Subject: RE: FAO Mrs A Gardner: Highways England response (our ref 85502) re. A/100/19/PL - Arundel Acre

For attention of:	Mrs A Gardner
Site:	Arundel Acre, Arundel Road, Angmering, BN16 4EU.
Development:	Change of use of land from agriculture for 3 No. travelling showpeople plots (Sui Generis) with associated storage barn, maintenance area, landscaping & infrastructure.
Your Reference:	A/100/19/PL
Highways England's Reference:	85502

Title REVISED ACCESS LOCATION AND ACHIEVABLE VISIBILITY SPLAYS

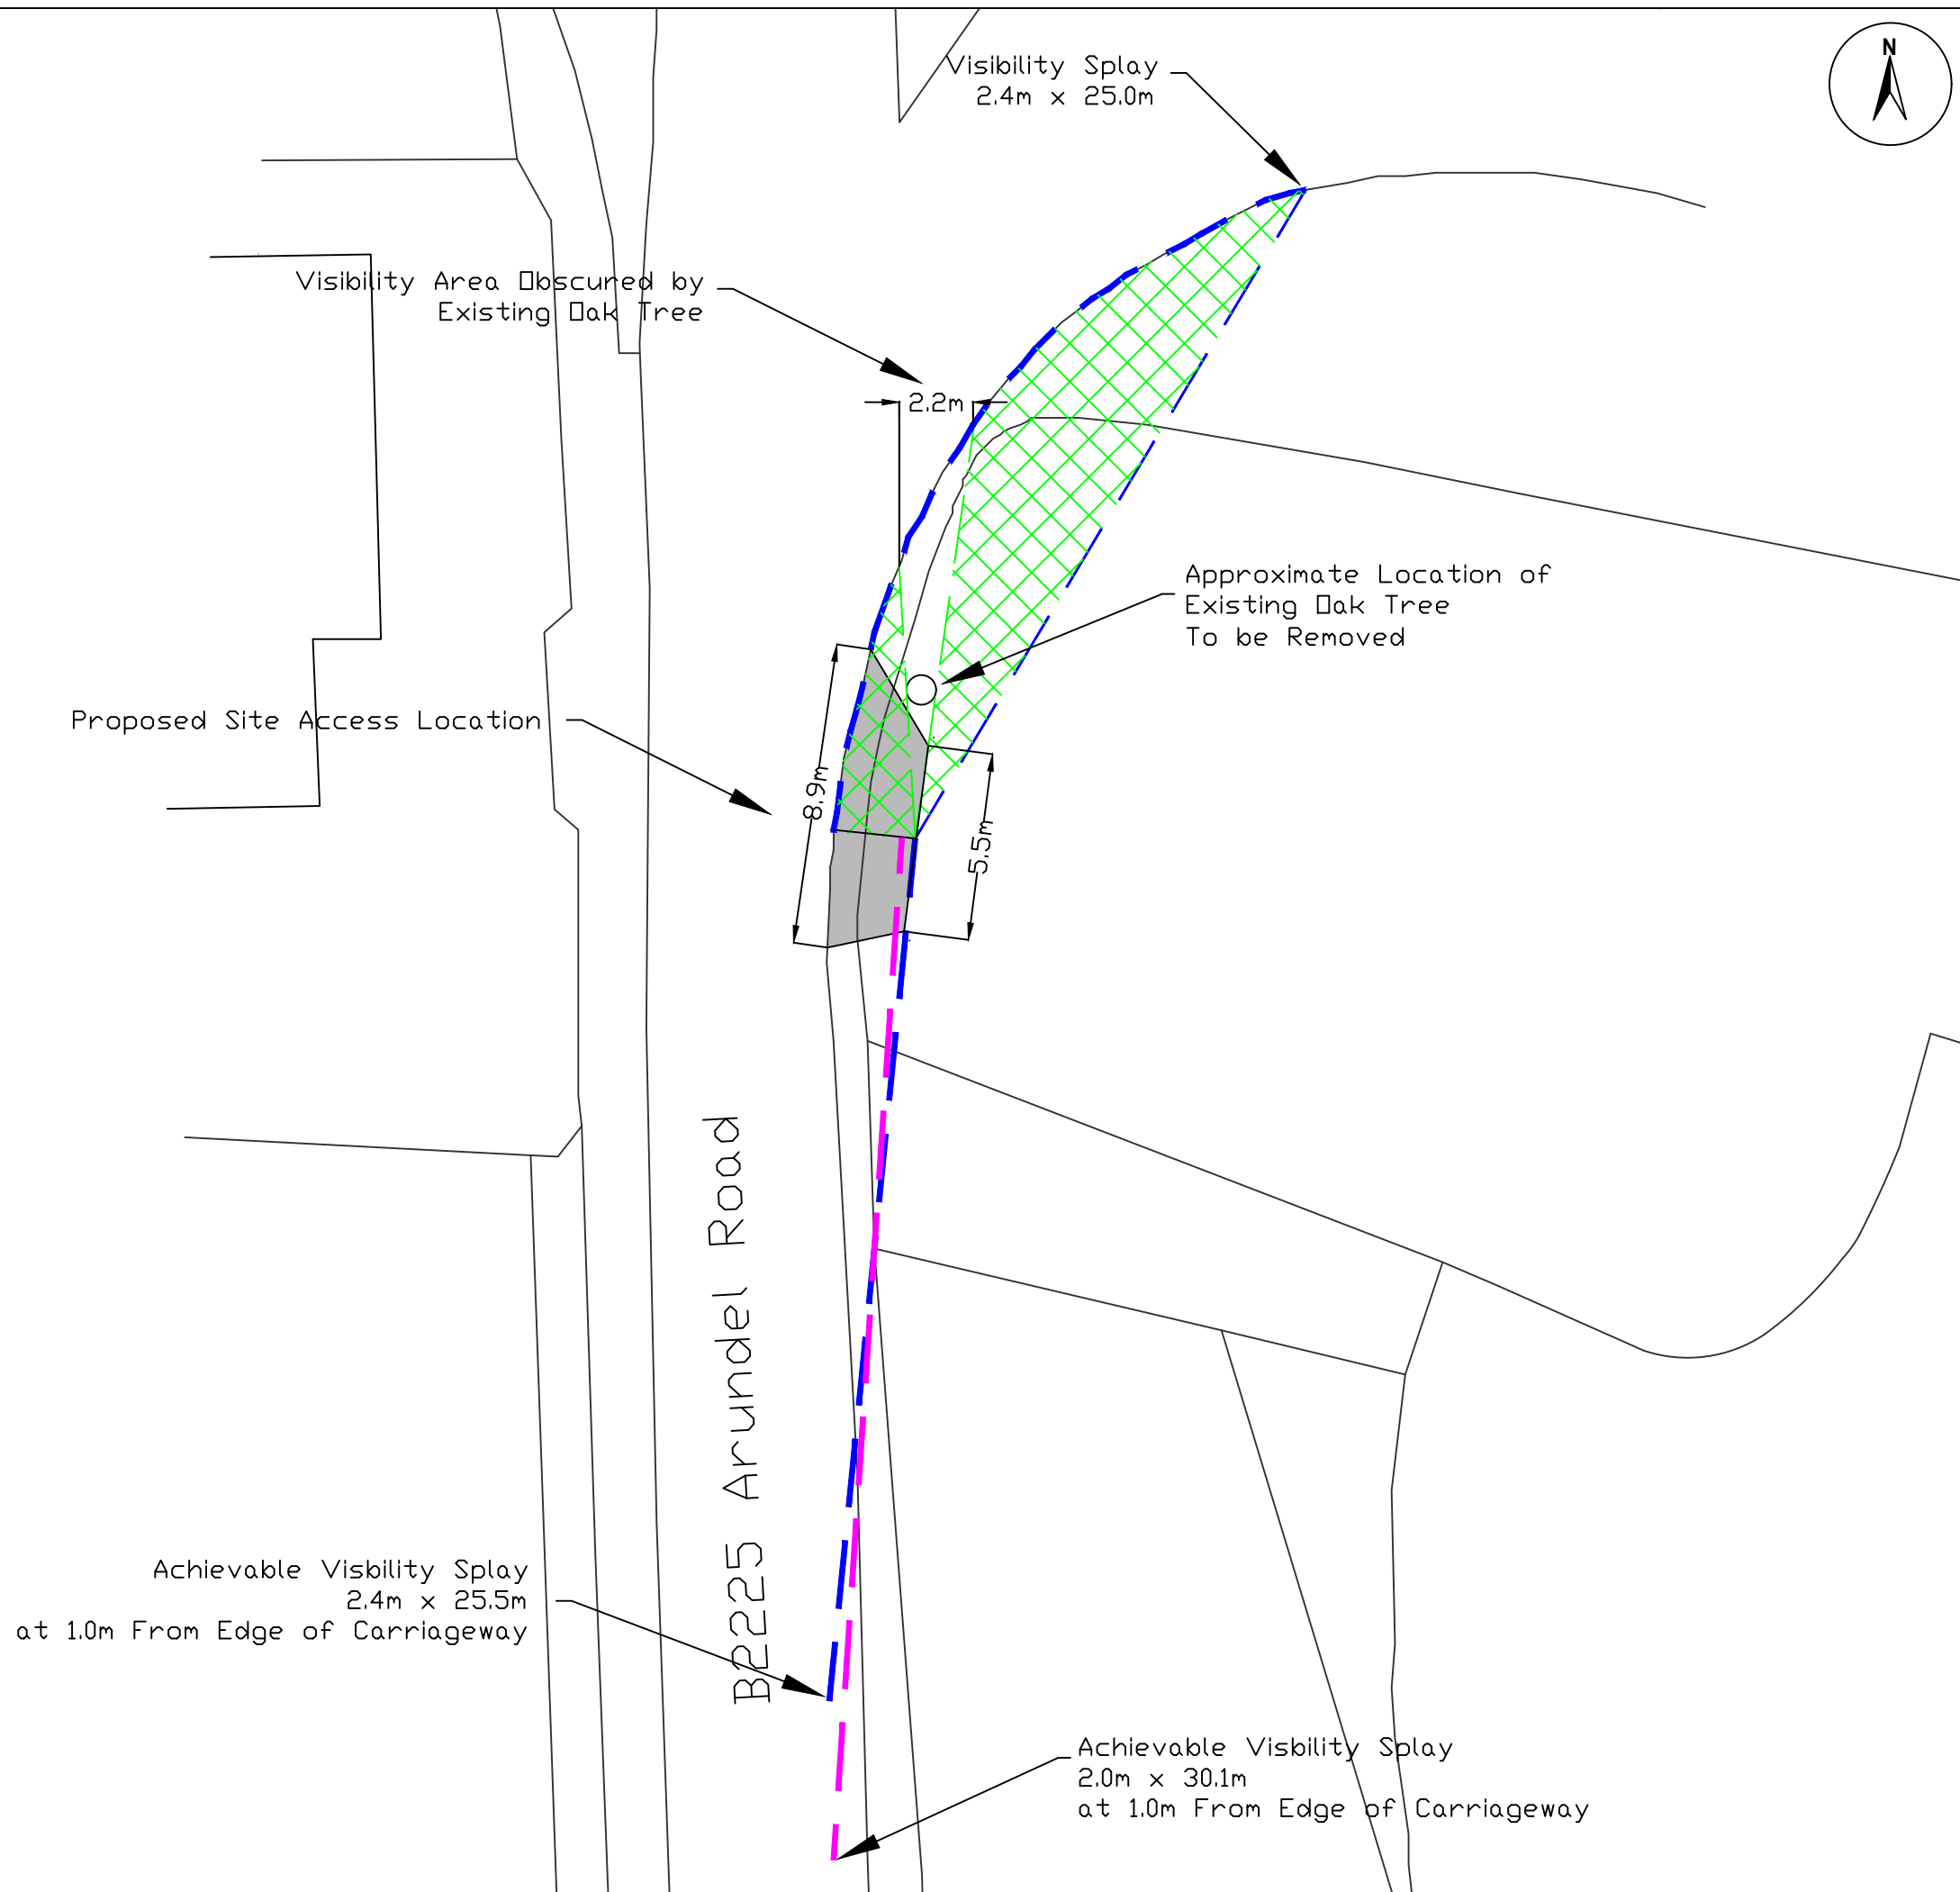
- The applicant will need to provide a plan to demonstrate that the appropriate visibility splays can be achieved to and from the site access and around the corner radius from the westbound A27 into the B2225 Arundel Road to the access in accordance with the minimum Stopping Sight Distance in *DMRB TD9/93 Highway Link Design* and *DMRB TD41/95 Vehicular Access to All Purpose Trunk Roads*. If this is not achievable and therefore cannot be robustly demonstrated, Highways England will be required to recommend refusal of the application because of the potential detriment to road safety.
